To:	DA Mattox
From:	Thomas Melville
Date:	March 27, 2018
Subject:	SAFEbuilt Permit Review – Design Team Comment Response

The purpose of the memorandum is to capture and provide response to SAFEbuilt Permit Drawing Review Comments for East Tower Expansion as received on March 23, 2018. Drawings are in the processes of being revised and are to be issued as Addendum No. 2 to direct the CM for revisions. Subsequent to this issuance, a full permit set will be issued to SAFEbuilt.

MMC EAST TOWER – BUILDING REVIEW

**A41-02**

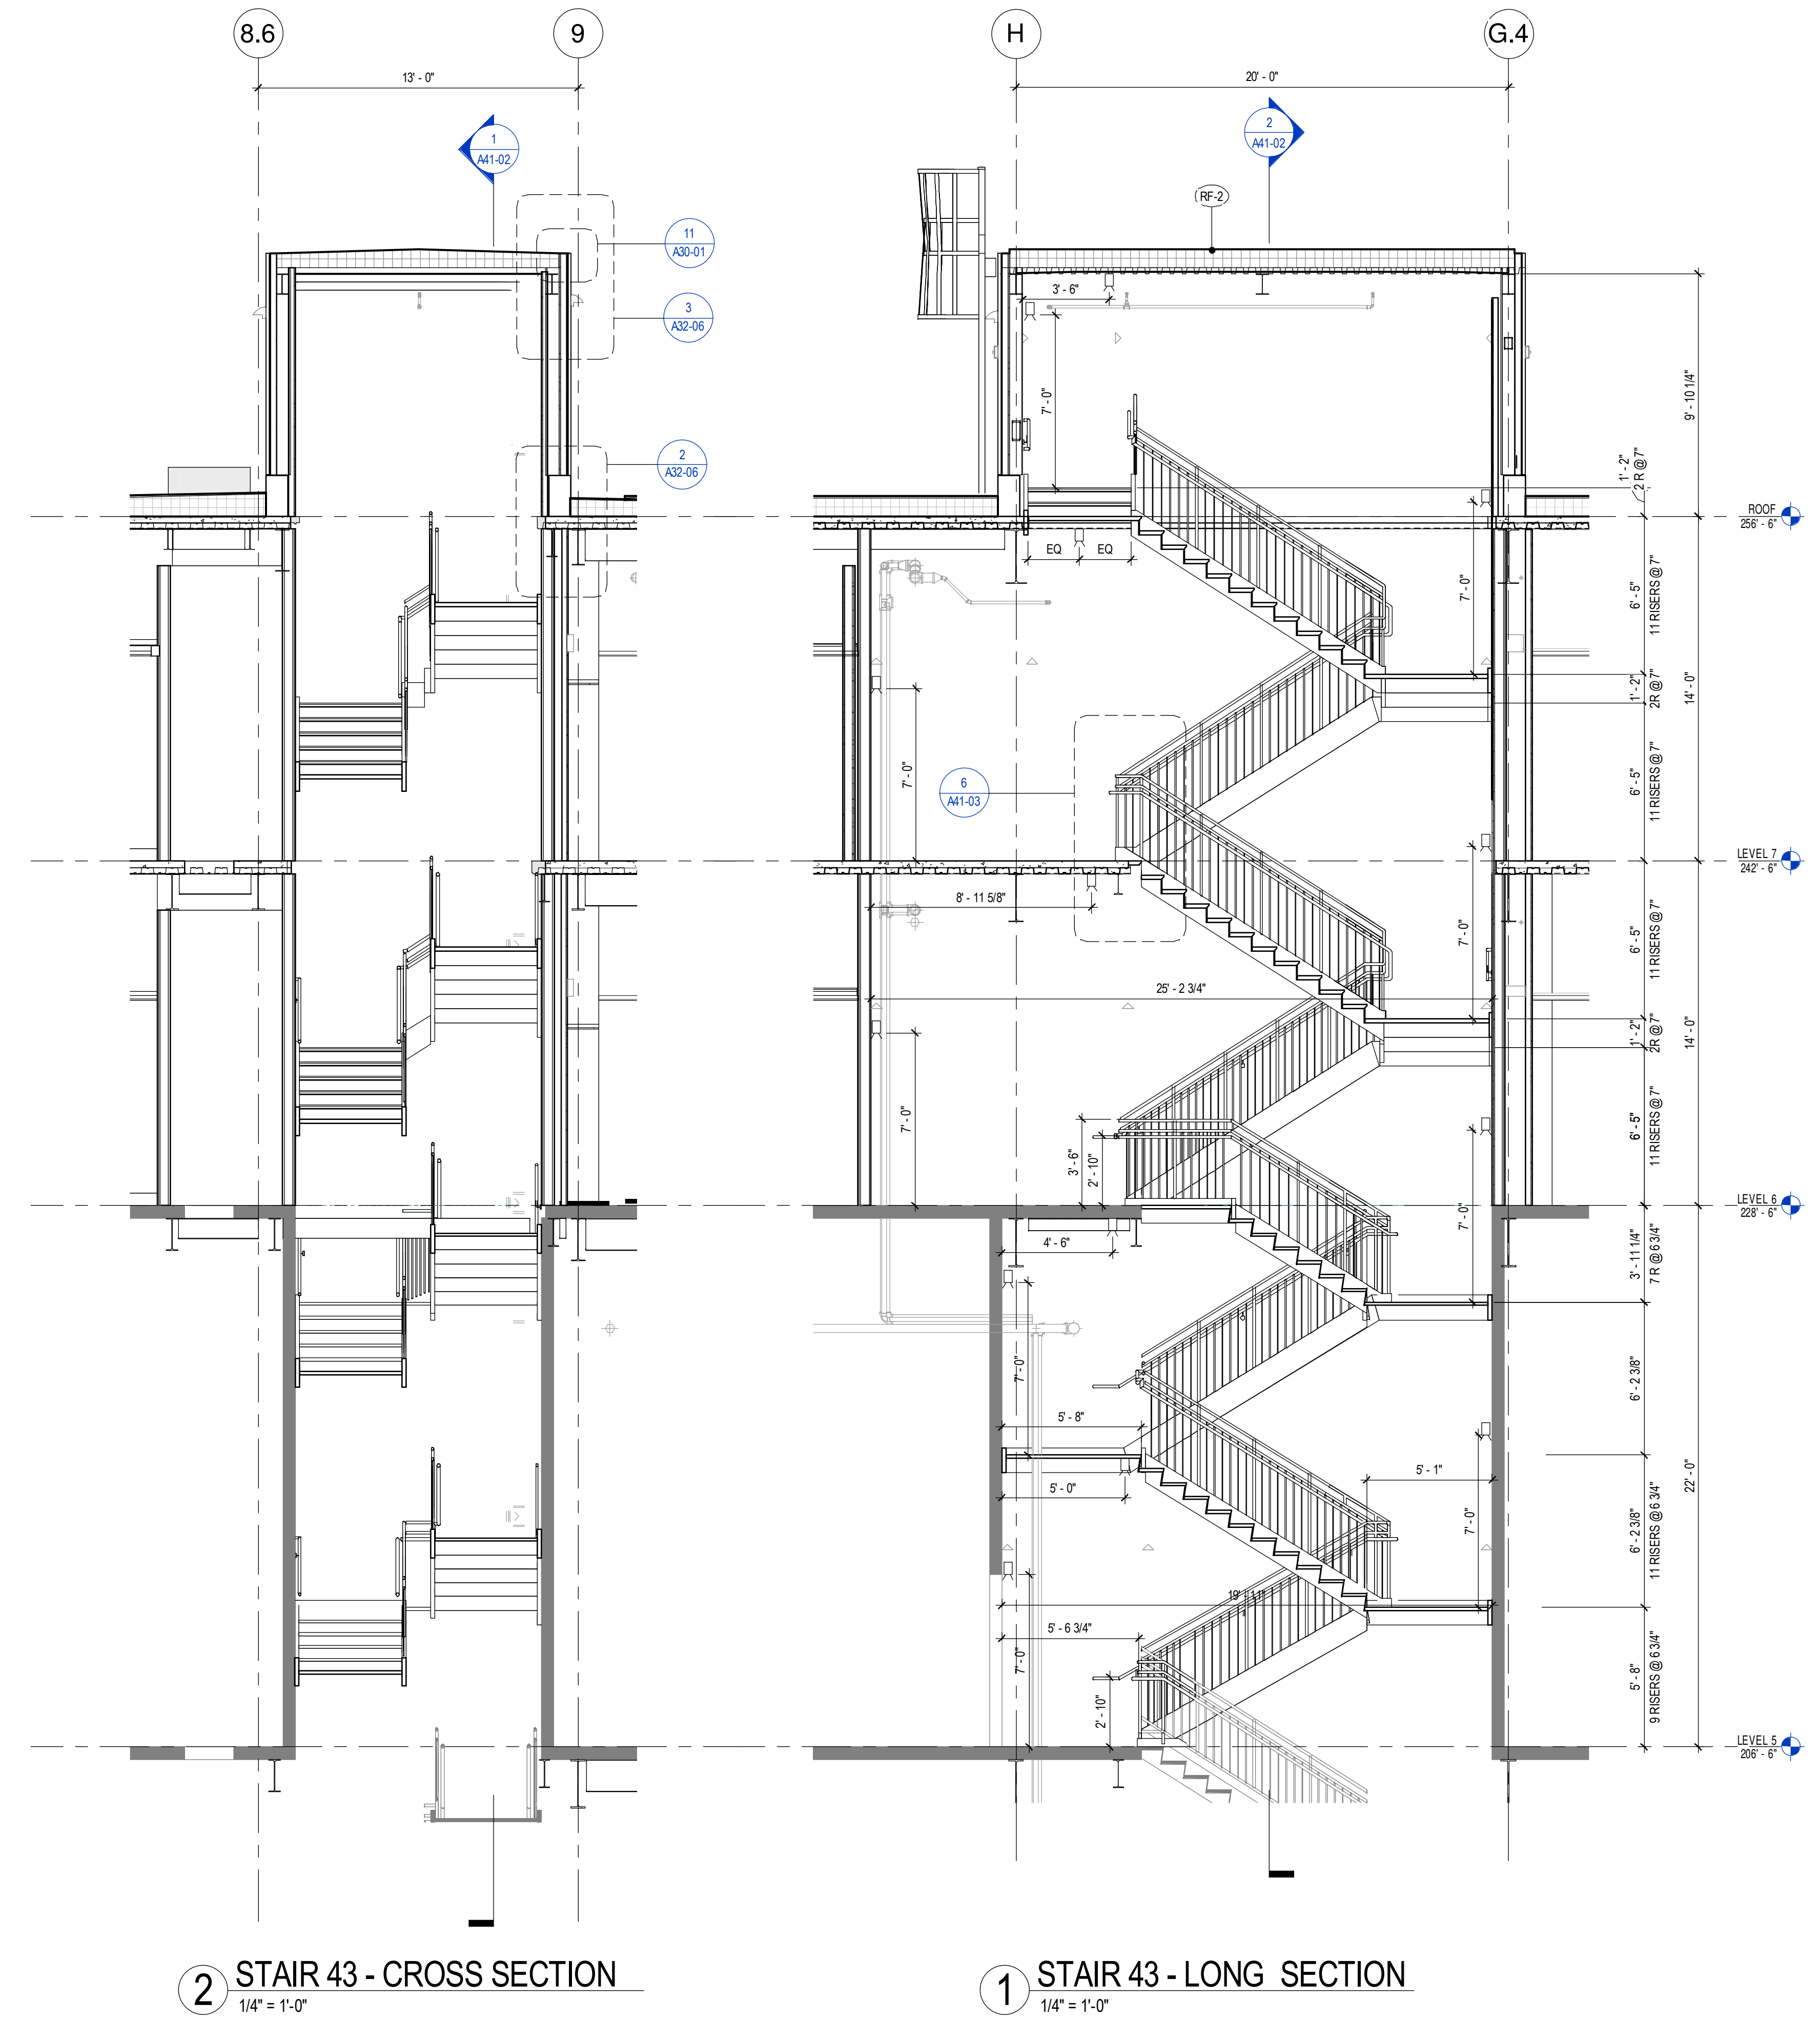
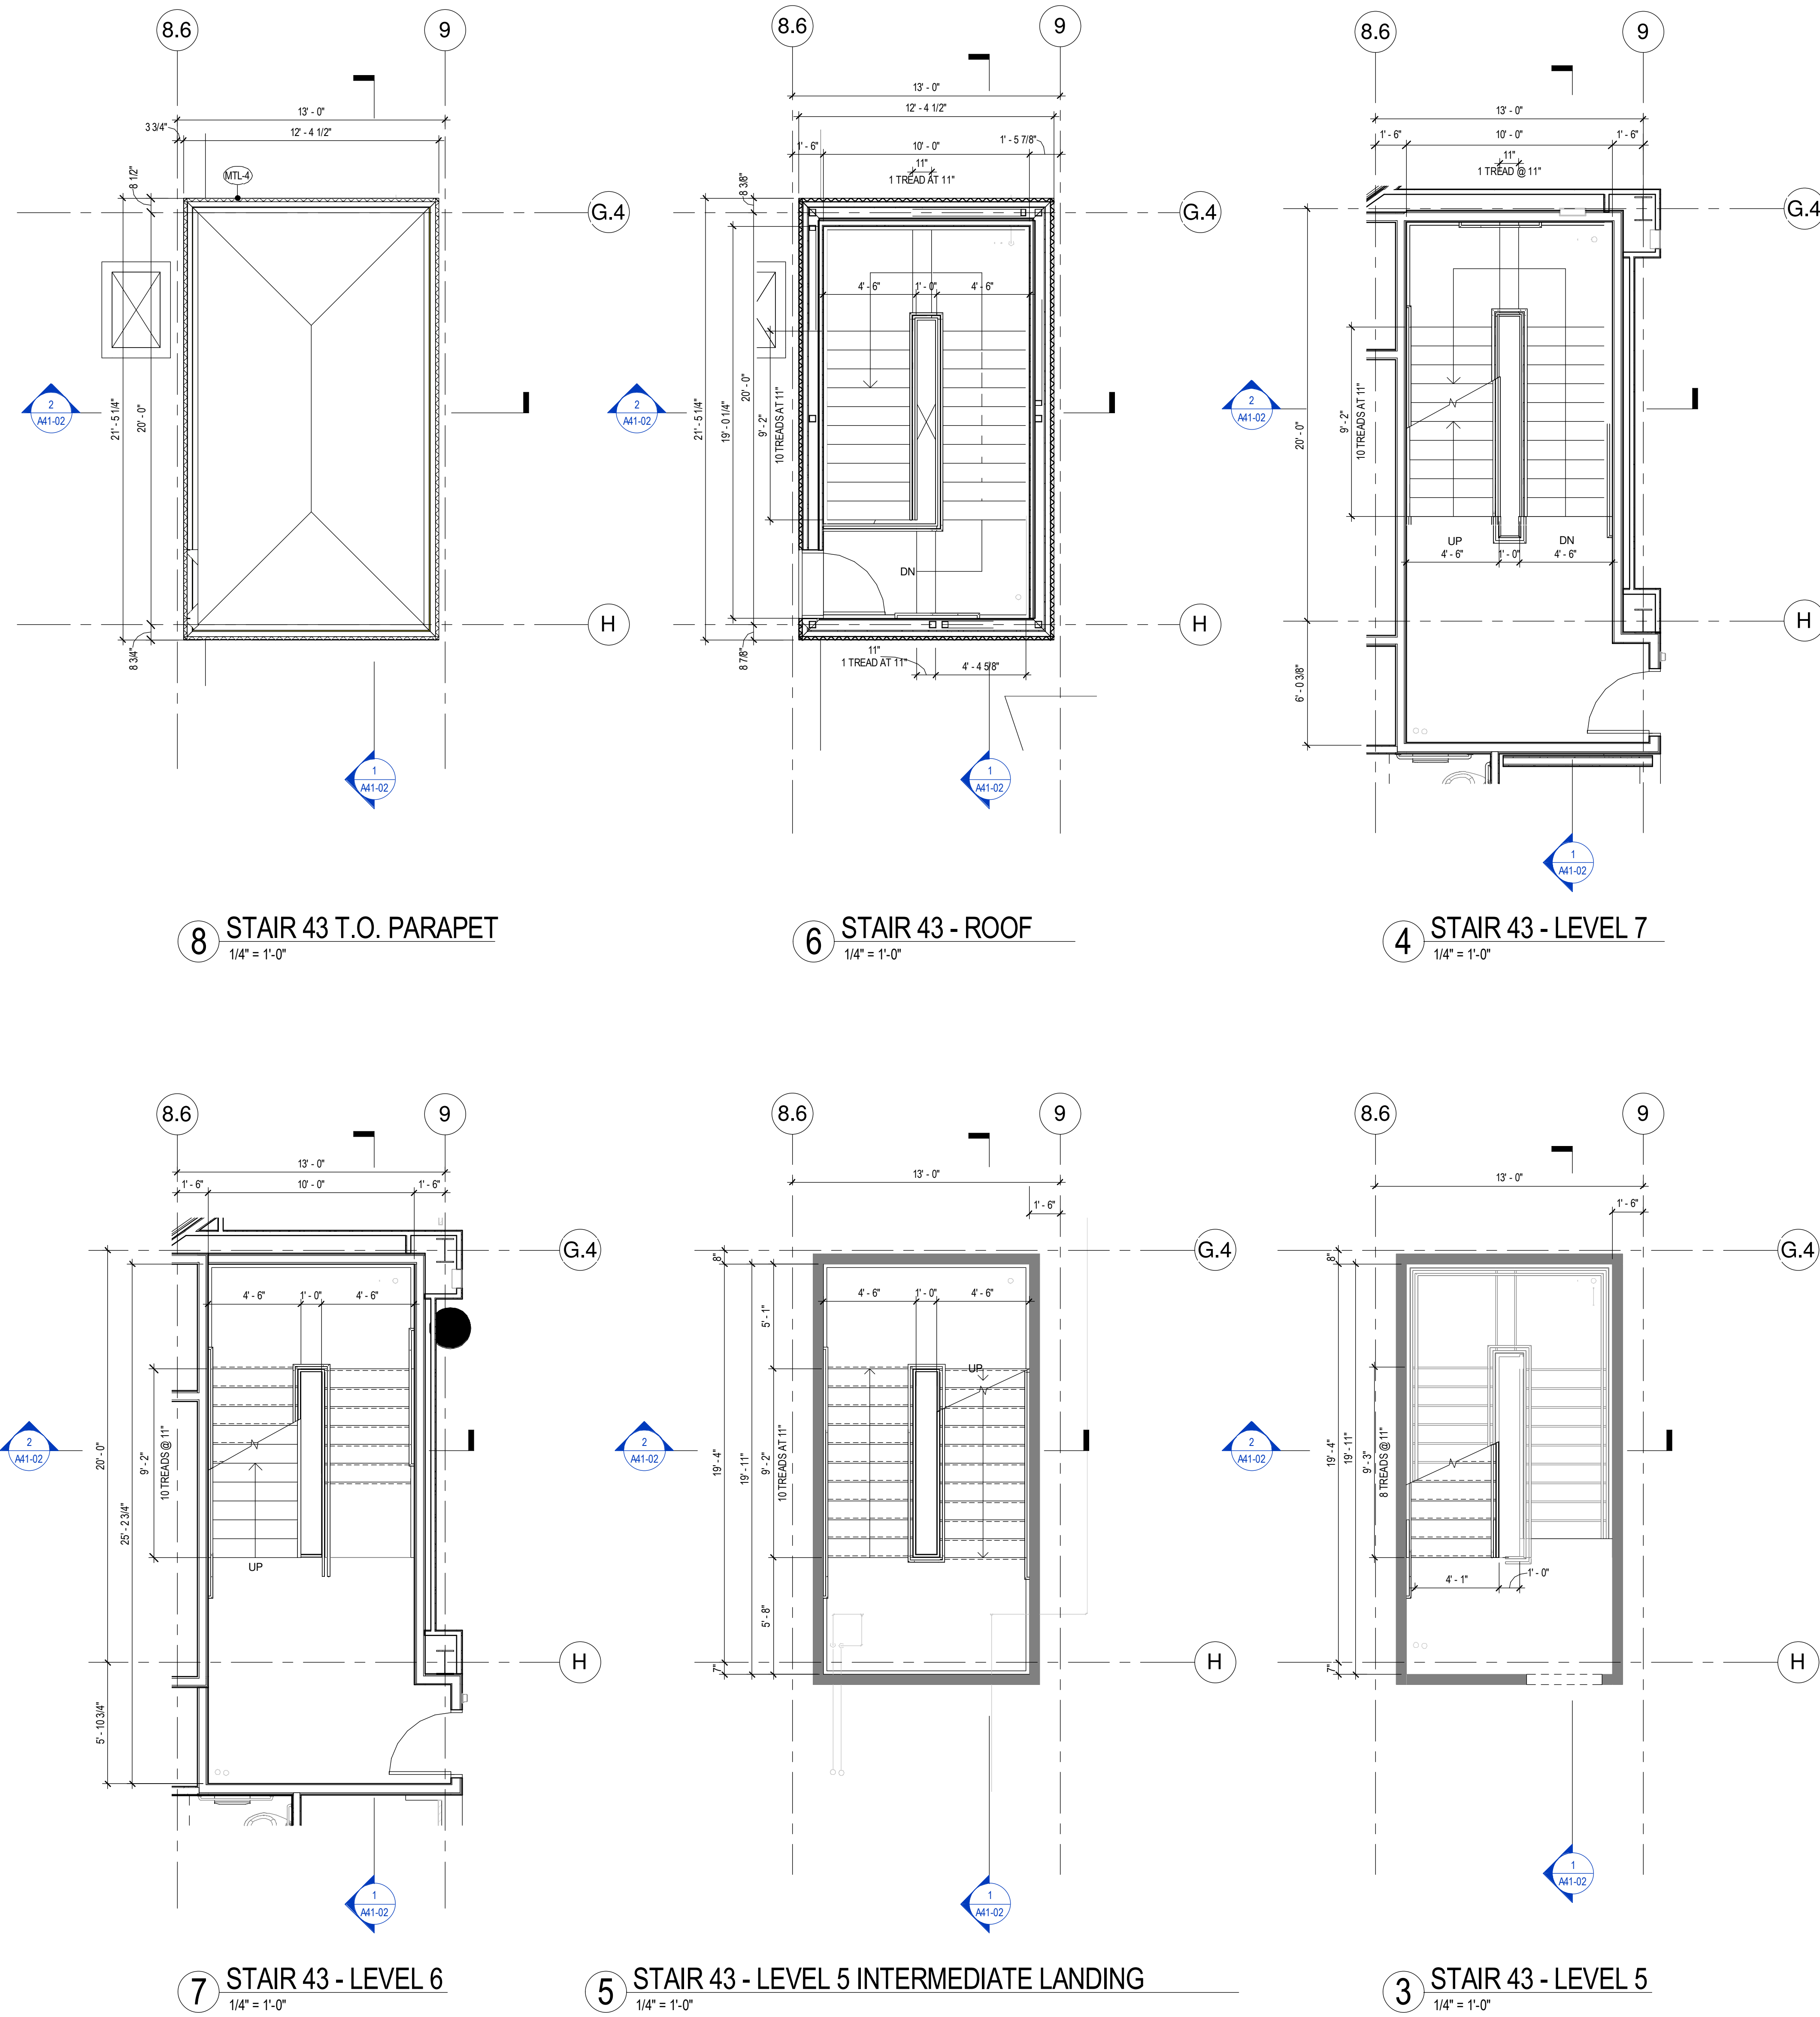
Per IBC 403.5.5 and 1025, luminous egress path markings are required in the interior exit stairs in accordance with IBC.

Required markings are currently indicated within the Documents on Sheets A41-01 and A41-02.

**INTERIOR
 PARTITION TYPES**

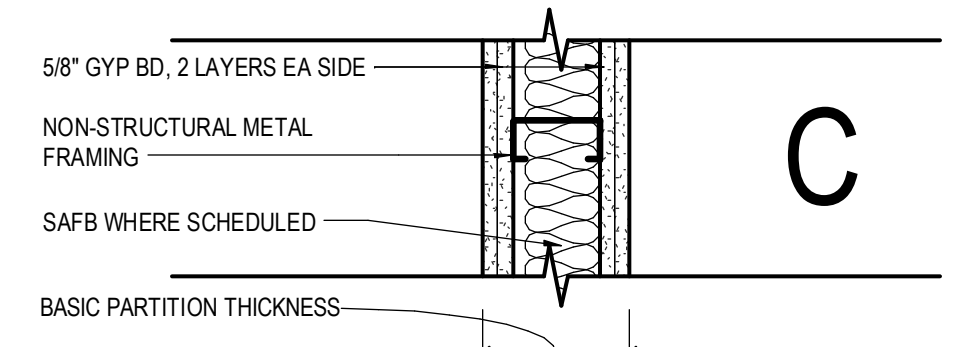
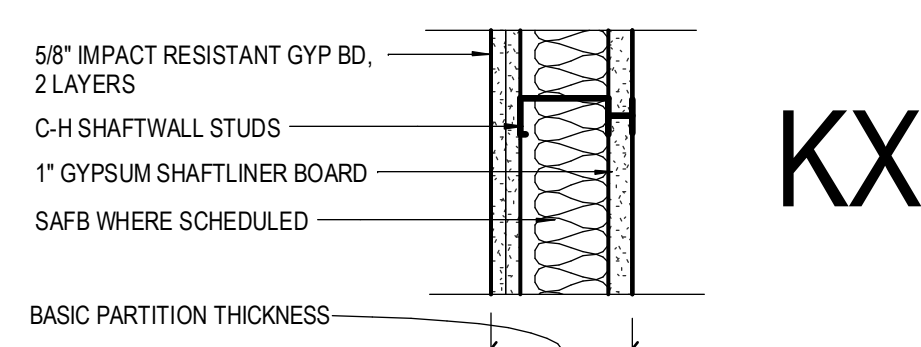
Per IBC 403.2.3.2, interior exit stairways and elevator hoistway enclosures shall be constructed of impact resistant materials in accordance with one of the three options included therein. Wall partition details C40 and K30 do not comply as currently drawn on sheet A61-01.

Drawings are to be revised and issued as Addendum No 2 within the Construction Documents indicating revisions to the partitions to provide impact resistant materials.
